From: [REDACTED]
To: [Metrowest1](#)
Subject: Chapel Pill Lane Access to Pill Tunnel
Date: 23 February 2021 12:39:30

FAO Planning Inspectorate. Metrowest Phase 1 Case Team ref TR040011

Drawing **PILL TUNNEL EASTERN PORTAL COMPOUND LANDSCAPING & ACCESS PLAN SHEET 1 OF 2**

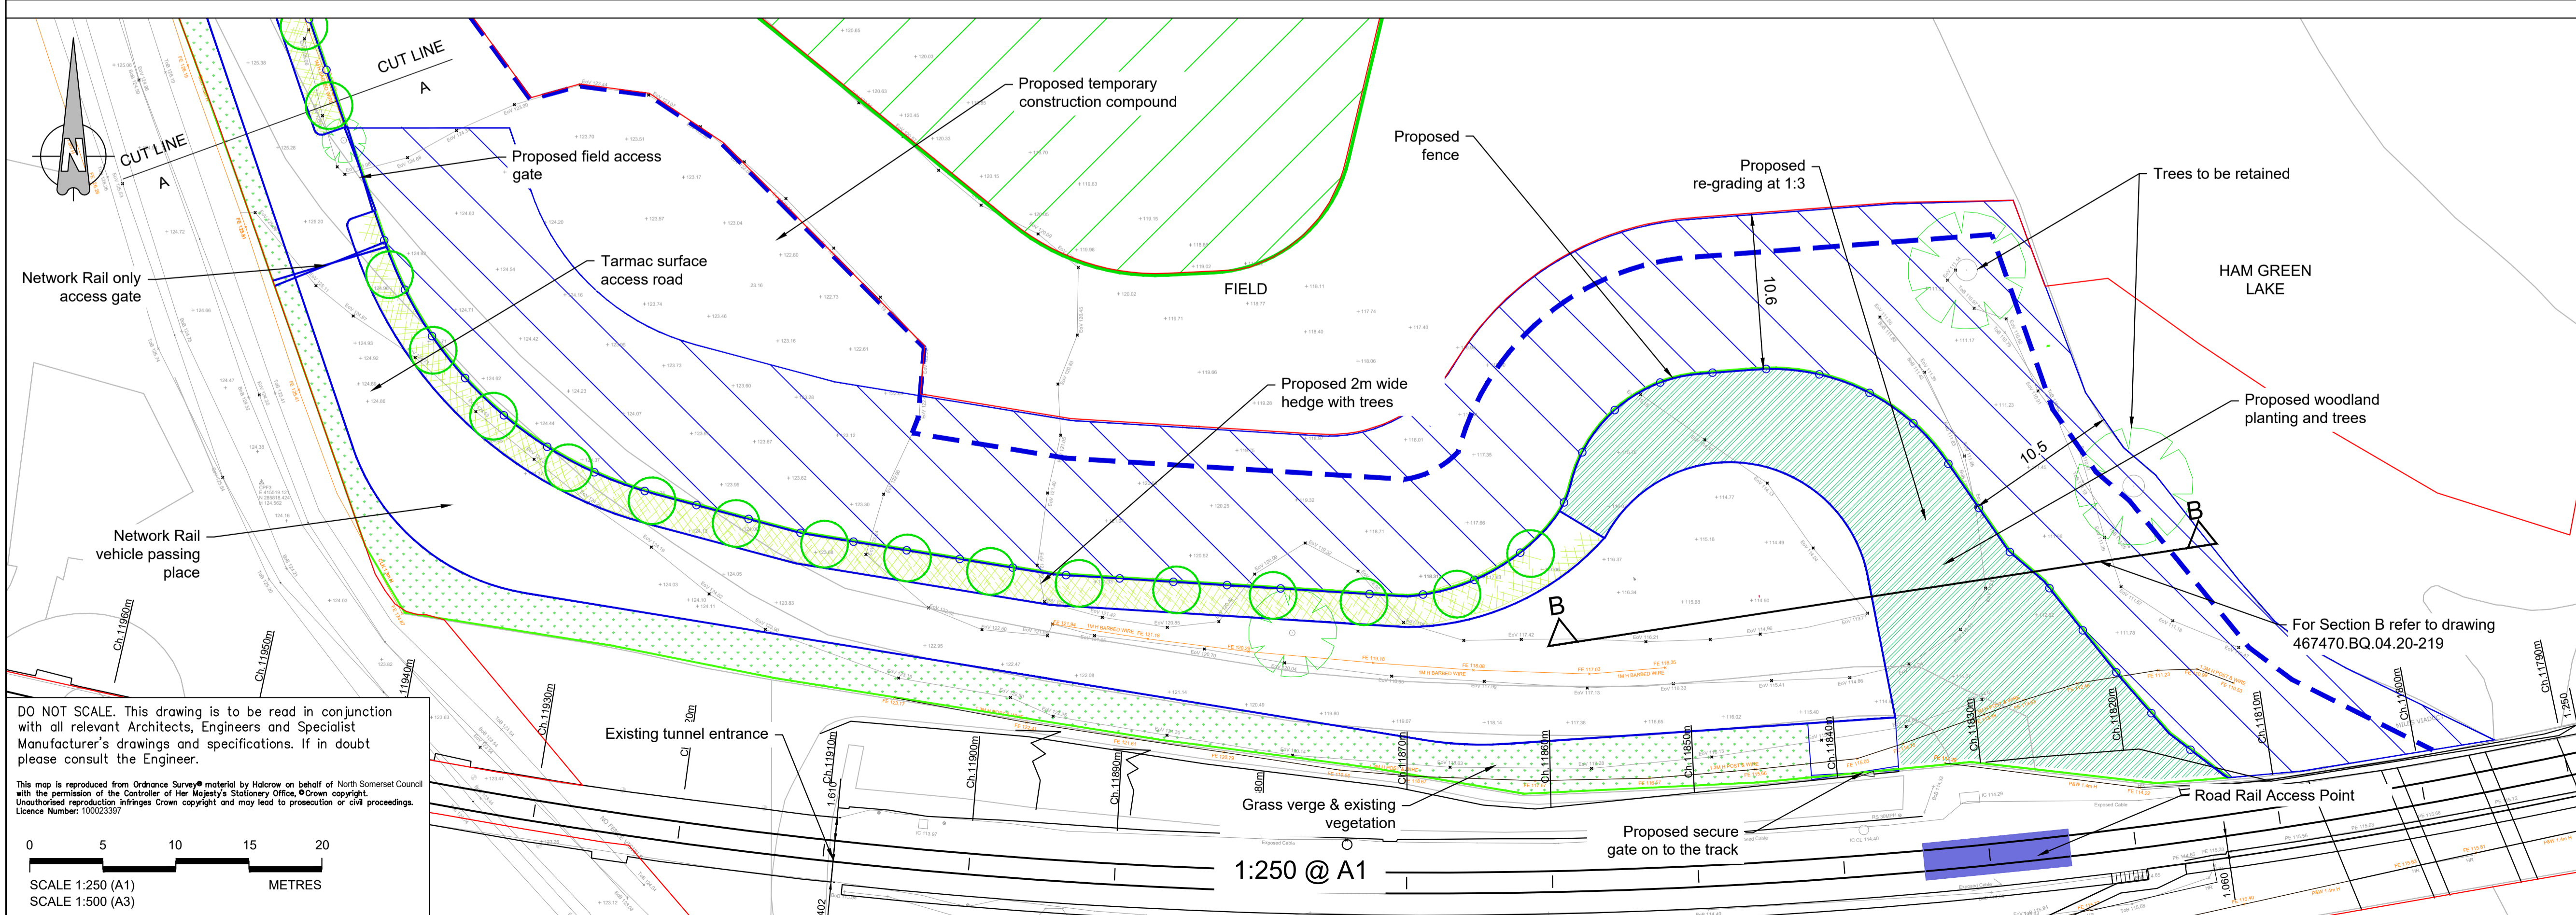
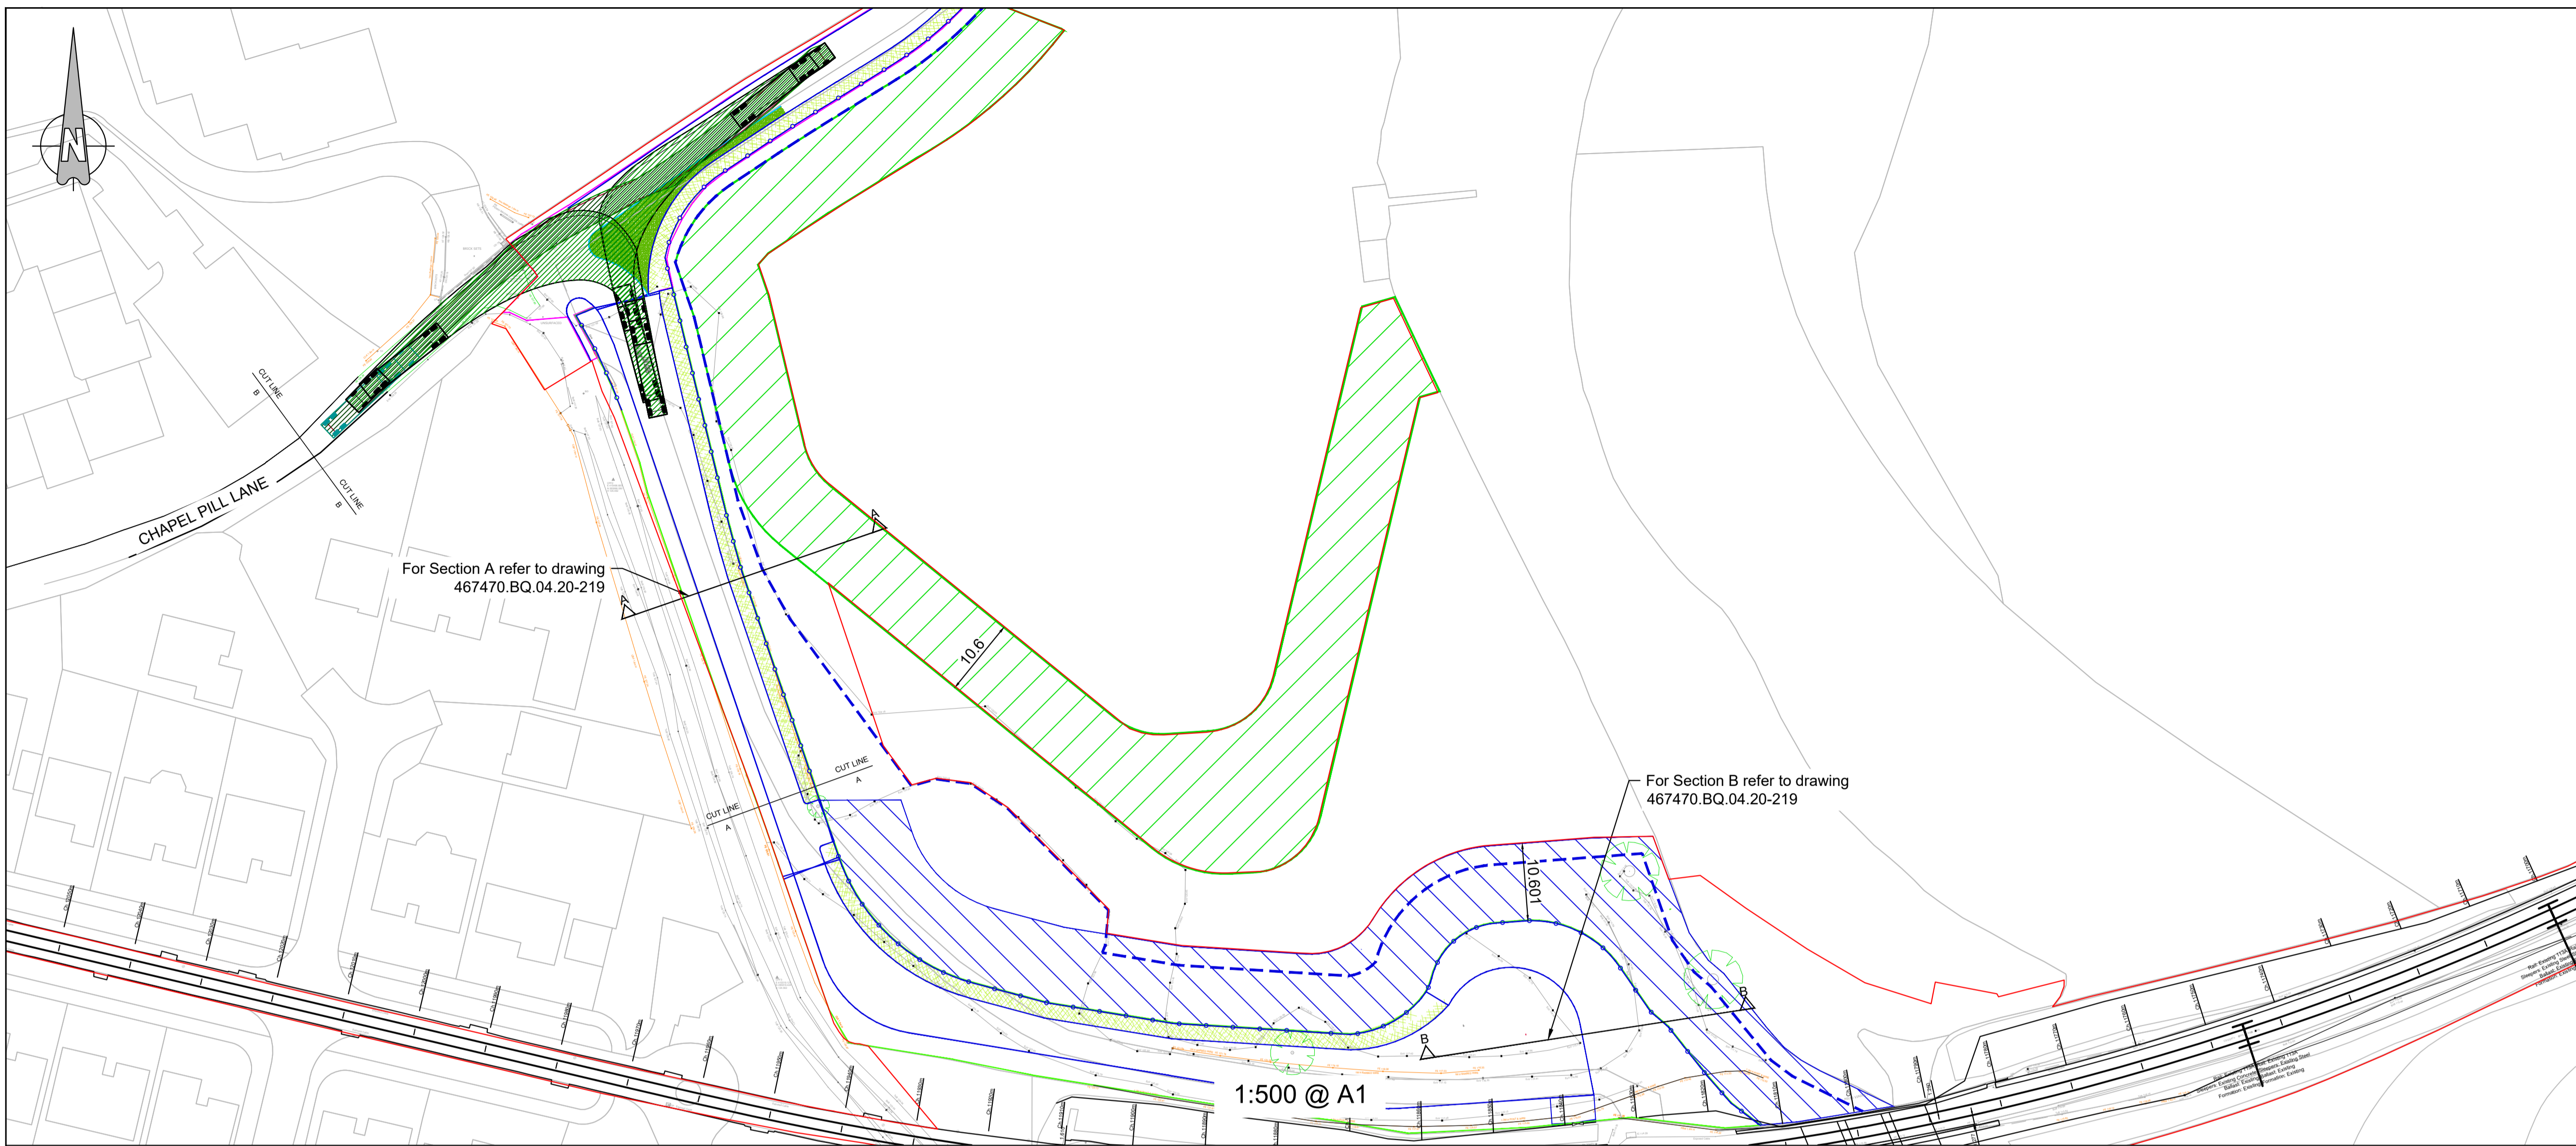
I have been made aware (through local concerns and the consultation information put forward by Alliance Homes in early February) that your intention to use Hayes Mayes Lane, as proposed in 2015, for your access to the Pill Railway Tunnel has been moved into the field adjacent to Hayes Mayes Lane.

If this is true then why?

It seemed sensible that you will need dedicated and exclusive access to the end of the tunnel for construction, maintenance and emergencies. The choice of an existing track appeared to be the most practical solution with the added benefit that it consumed the minimal amount of a Green Belt field.

The revised proposal will consume a sizeable quantity of open Green Belt land, will not be exclusively for your use in an emergency and could endanger lives in the event of an accident in the tunnel and opens the way to half of the field to be used for a housing development in a Green Belt field whose ecology supports that of a lake of noted wildlife importance.
